KITTITAS COUNTY

DEPARTMENT OF PUBLIC WORKS

MEMORANDUM

TO: All Staff
FROM: Public Works Plan Review Team
DATE: September 27th, 2023
SUBJECT: Public Works Comments: SE-23-00016 Ritter

NEW ROAD PROPOSAL -
APPLICANT -
JIM RITTER, POA
FOR WILLIAM P. WOODS, JR.
E-MAIL - JAMESRITTER@GMAI.
206-949-9143.

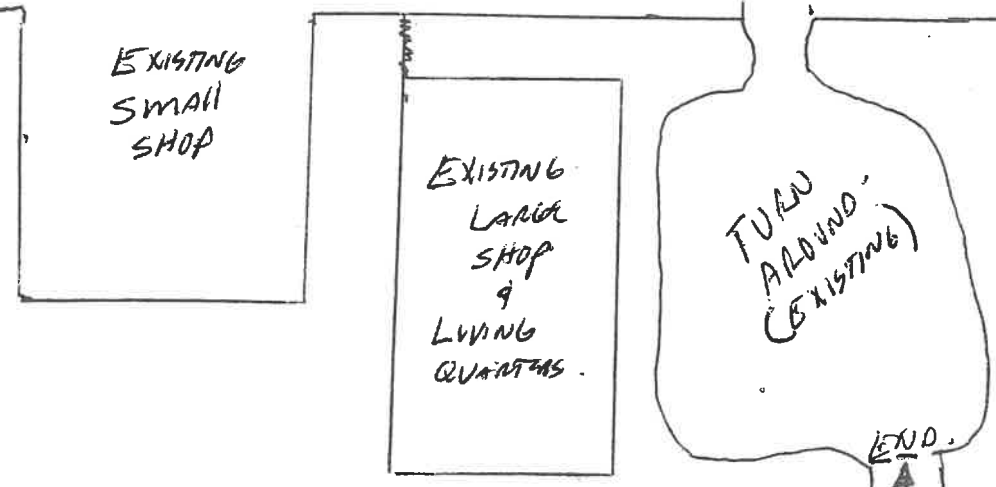
SURVEY	<p>The current lot configuration has the existing large shop on Parcel #664234, with the proposed access crossing over Parcel #10847.</p> <p>This will have to be resolved by either a Boundary Line Adjustment to match the lot lines shown on the site plan, with the Large shop on Parcel #10847, or by a "Reservation of Easement" over Parcel #10847 for the benefit of the Large Shop on Parcel #664234.</p>
TRANSPORTATION CONCURRENCY	No comments
FLOOD	Parcels 10847 and 664234 are not mapped in the FEMA identified special flood hazard area (100-year floodplain). (SC)
WATER MITIGATION/ METERING	No comments. (SC)
